# CITY OF ALBUQUERQUE

PLANNING DEPARTMENT – Development Review Services

RE: **North Valley Clinic  
Grading & Drainage Plan  
Engineer's Stamp Date 6-12-2014 (File: G14D086)**

GRADING and DRAINAGE PLAN

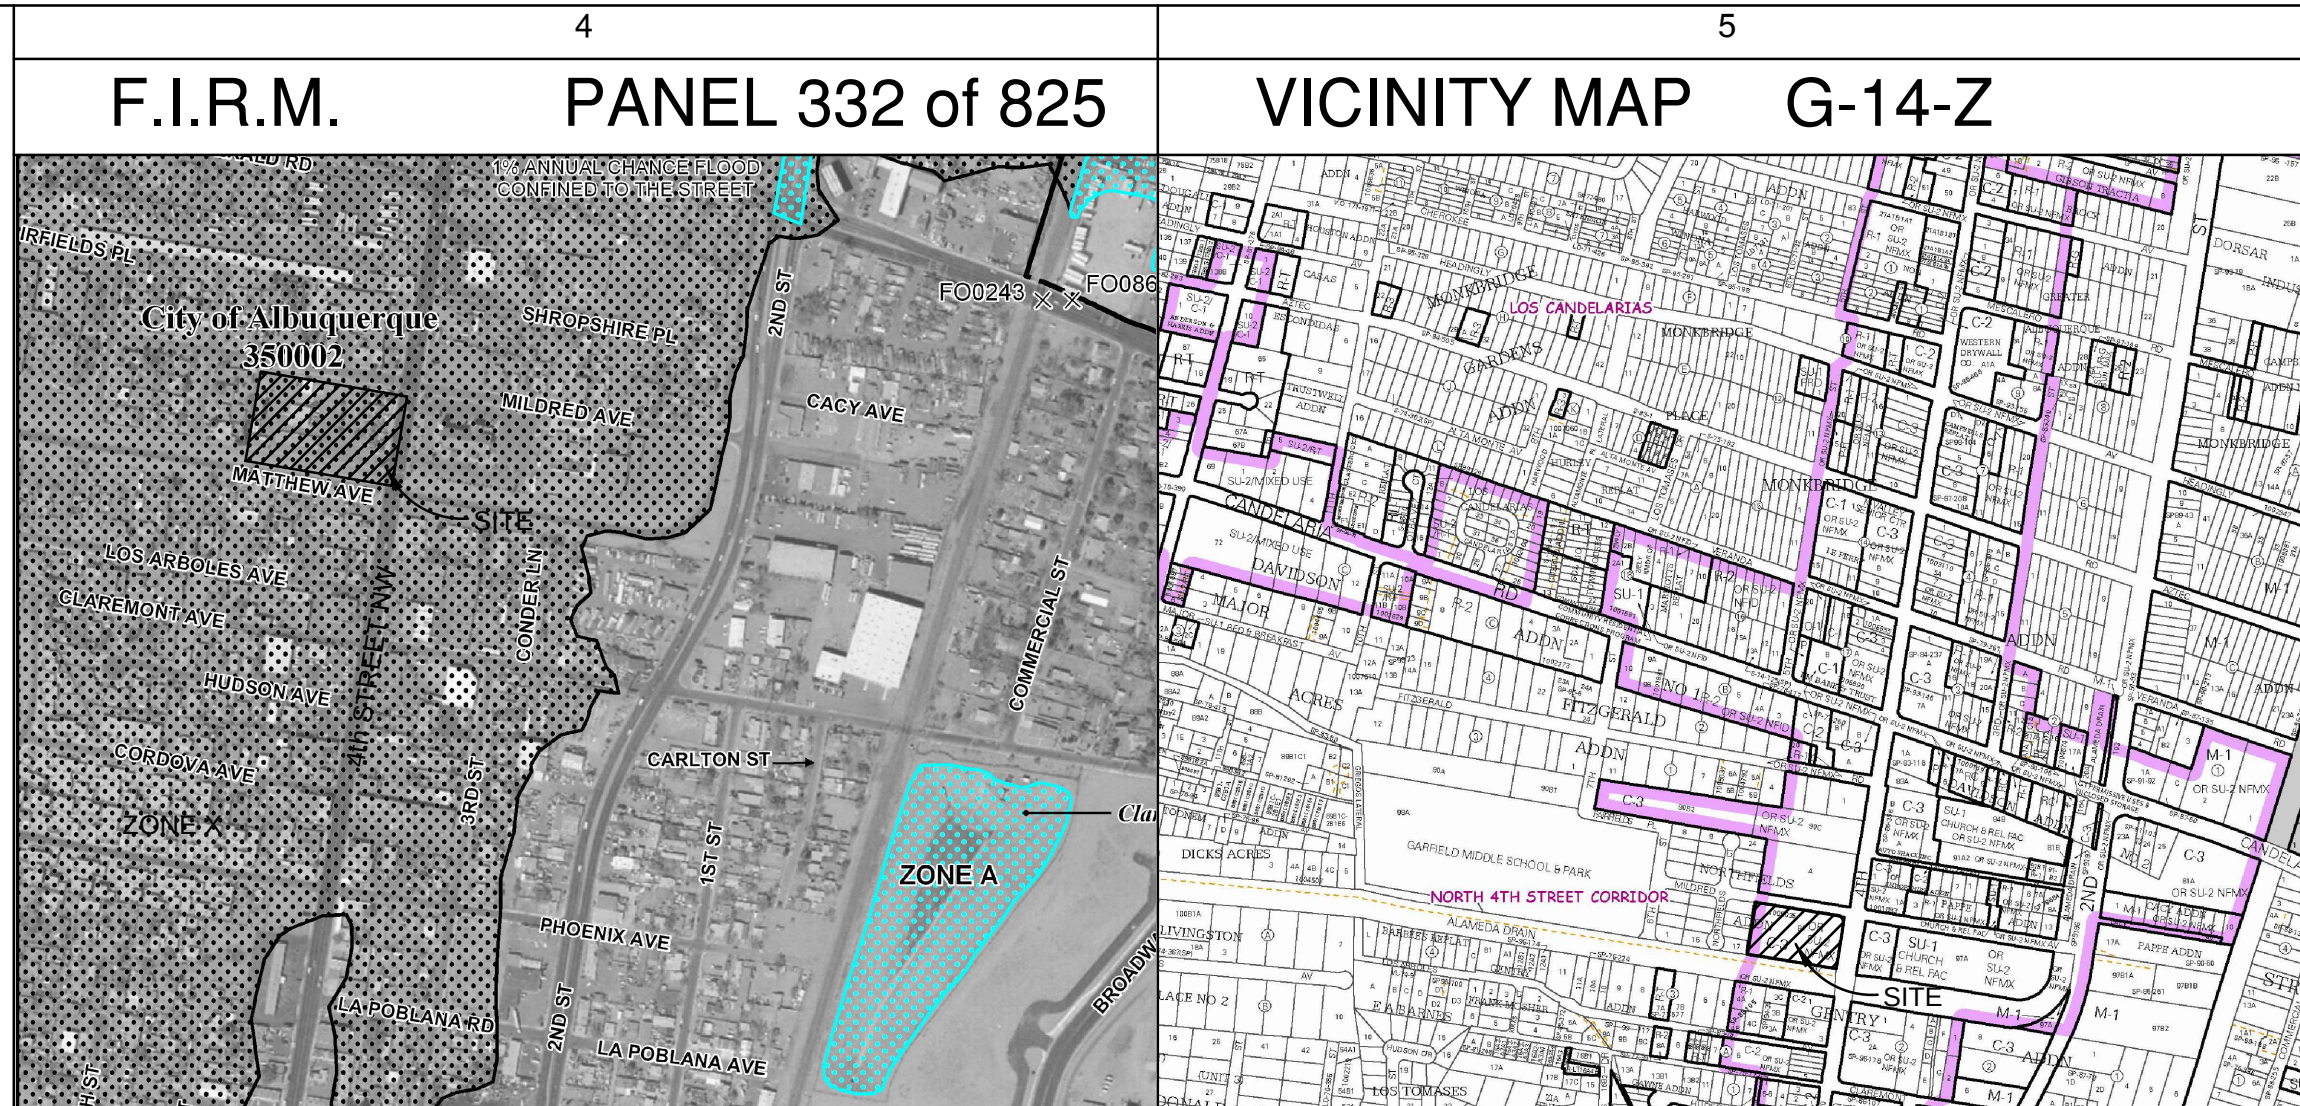
1. On the title sheet, include a design narrative summarizing the drainage scheme, describe offsite flows, and how the "first flush" will be managed. There does not appear to be a method to capture the first flush from the roof drainage or portions of the parking lot.
2. In the valley, discharge is limited to 2.75cfs per acre.
3. Provide calculations showing the 12" SD Mildred has capacity for additional discharge.
4. Provide waterbreaks at driveways
5. Hydrology calculations show 77% Land Treatment D, but a rough estimate shows it to be more about 88% D.
6. If water harvesting or first flush is to be captured within the medians in the parking lot, indicate with keyed note and grade towards the medians.
